Principle Area of Disagreement Statement

North Yorkshire County Council and Richmondshire District Council

Drawing Title: De-Trunking Plan Regulation 5(2)(o)
 Sheet 1 of 1

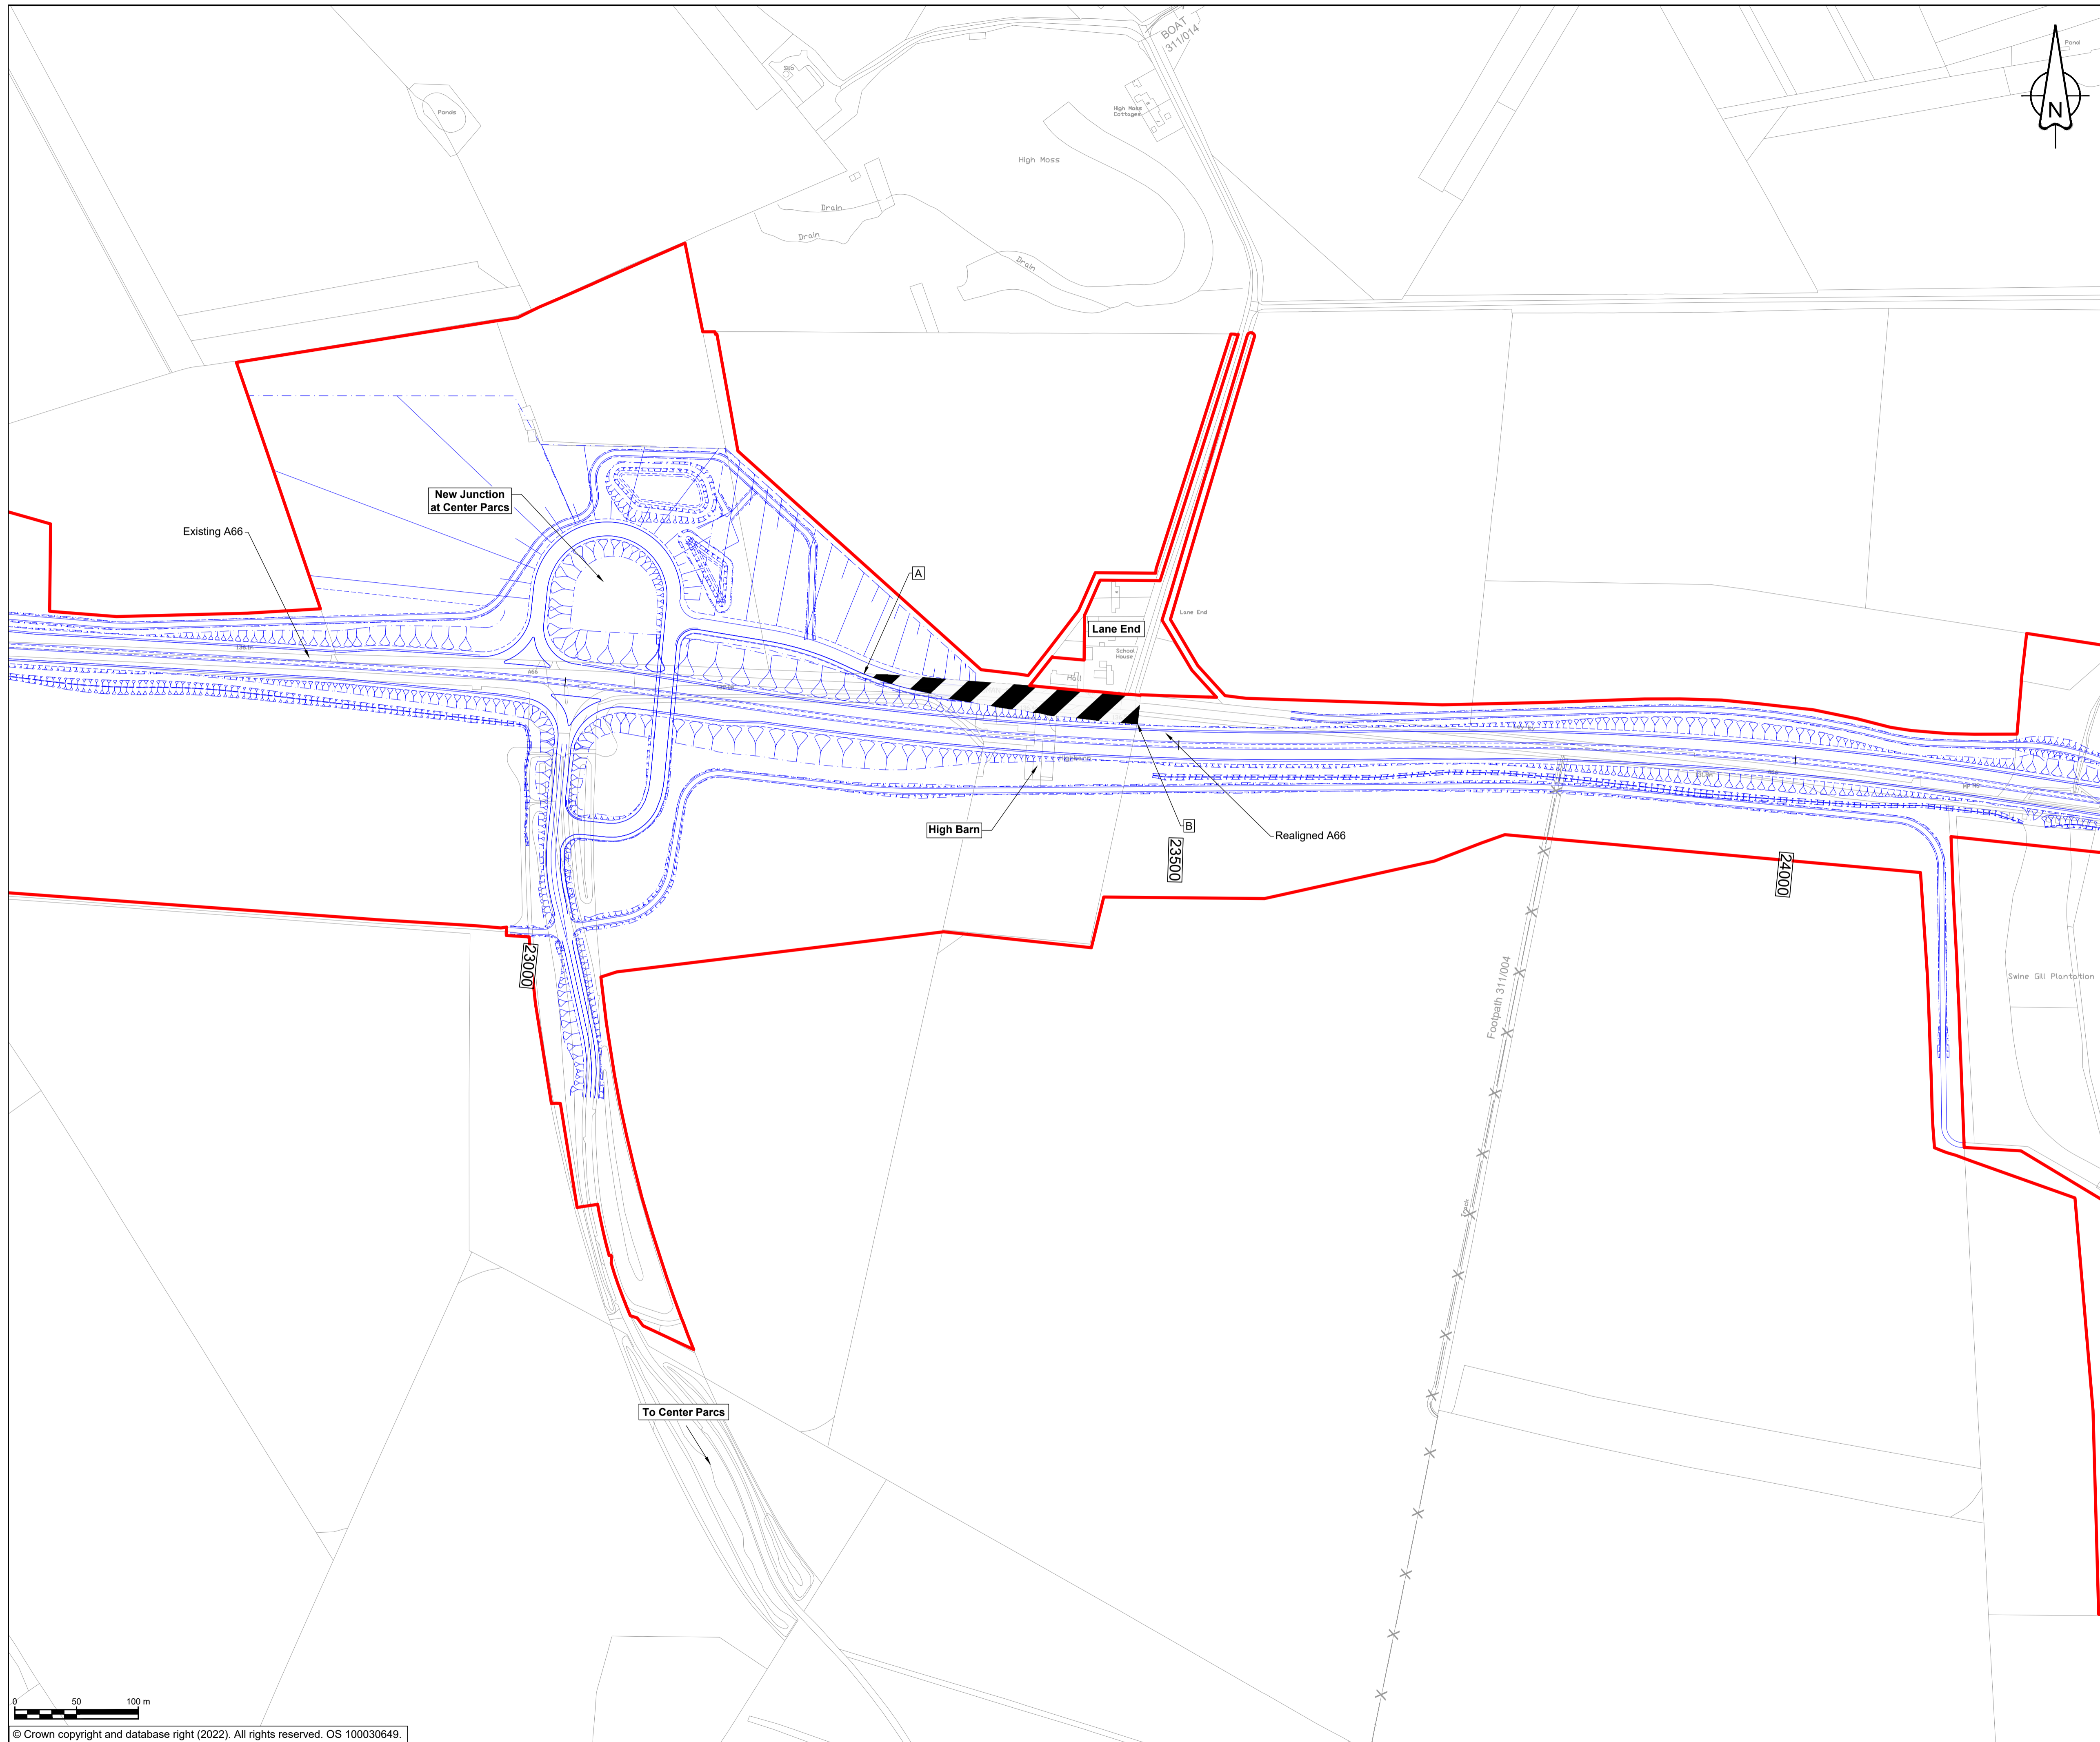
operational period of the route and that, where necessary, upgrades are delivered on the local road network to support this. Currently within the DCO submission there are no traffic management details included for the scheme.		
Highway Design	A clear and detailed strategy is required for the section of the A66 that is to be “de-trunked”. It is assumed that any “de-trunked” sections of the existing A66 do not include a maintenance backlog, and that commuted sums will be provided by National Highways to support future up keep. We also consider that transferred sections of the route should be subject to enhancements where these are considered to best reflect their new role, for example improved junction arrangements or the introduction of improved facilities for non-motorised users.	The continued development a clear de-trunking strategy is required. Continued discussion as to commuted sums and enhancements is required	Likely
